**RE: 6/2023/1347/COND – Land to the North-East of King George V Playing Fields, Northaw Road, East Cuffley, Hertfordshire, EN6 4RD**

Thank you for your consultation on the above site, received on 6 July 2023 for the submission of details pursuant to condition 19 (Flood Risk Assessment), on planning permission S6/2015/1342/PP for the residential development of up to 121 dwellings, associated infrastructure, and a change of use from agricultural land to an extension of the King George V playing field.

- Surface Water Drainage Report (Rev 5), Prepared by Brookbanks, Ref: 10929/SWD rev4, 28 June 2023.
- Surface Water Flood Modelling Technical Note (Rev 2), prepared by Brookbanks, Ref 10929/TN01, Rev 2, 28 June 2023.

**Figure 4-4 Flood depth difference Baseline vs Development, 1h duration 1 in 100yr+40%CC**

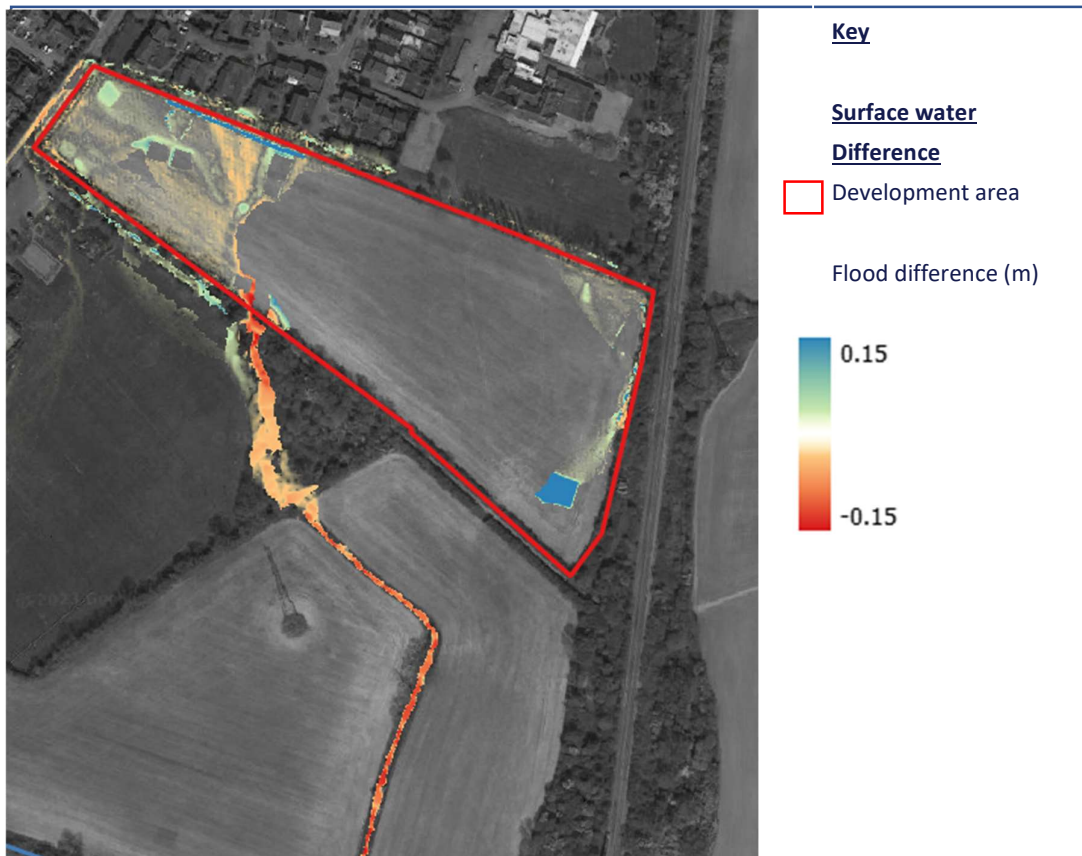
- There is no additional commentary in updated documents to show how flood risk is not increased elsewhere from the change in flow velocities to the water course from the current land use of a field to a culvert.

Figure 5-5 Maximum flood depth Surface water Development scenario, 1h duration 1 in 100yr+40%CC

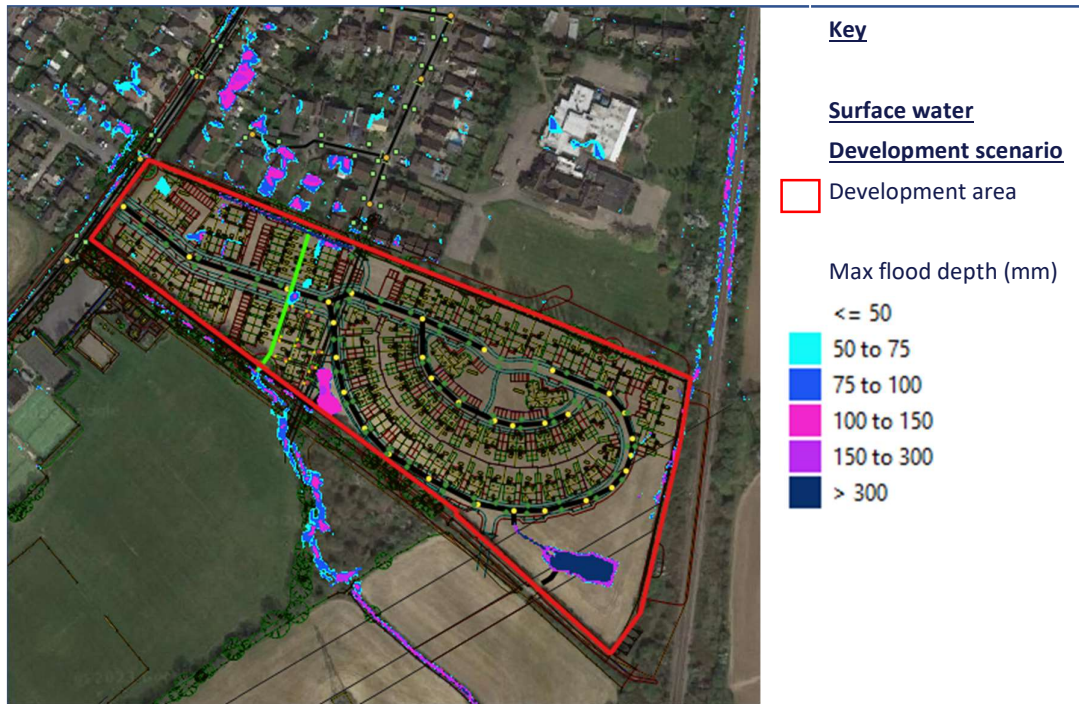
- The details of the design to manage the overland flow route has been modified from a cut off trench and French drain to a cut off trench and dry culvert. This means the surface water flow path would be managed, independently of the proposed drainage network.

- Despite the cut off ditch and culvert being an independent system, there is no specific exceedance flow plan to show how impacts of exceedance flood events (greater than the design flood event or failure of the structure) would be minimised. The Surface Water Modelling Technical Note Rev 2, 28 June 2023 (Section 5.15) does contain a modelling scenario without the mitigation in place which would give an indication of the worst-case scenario of the culvert blocking and the cut off ditch overtopping.
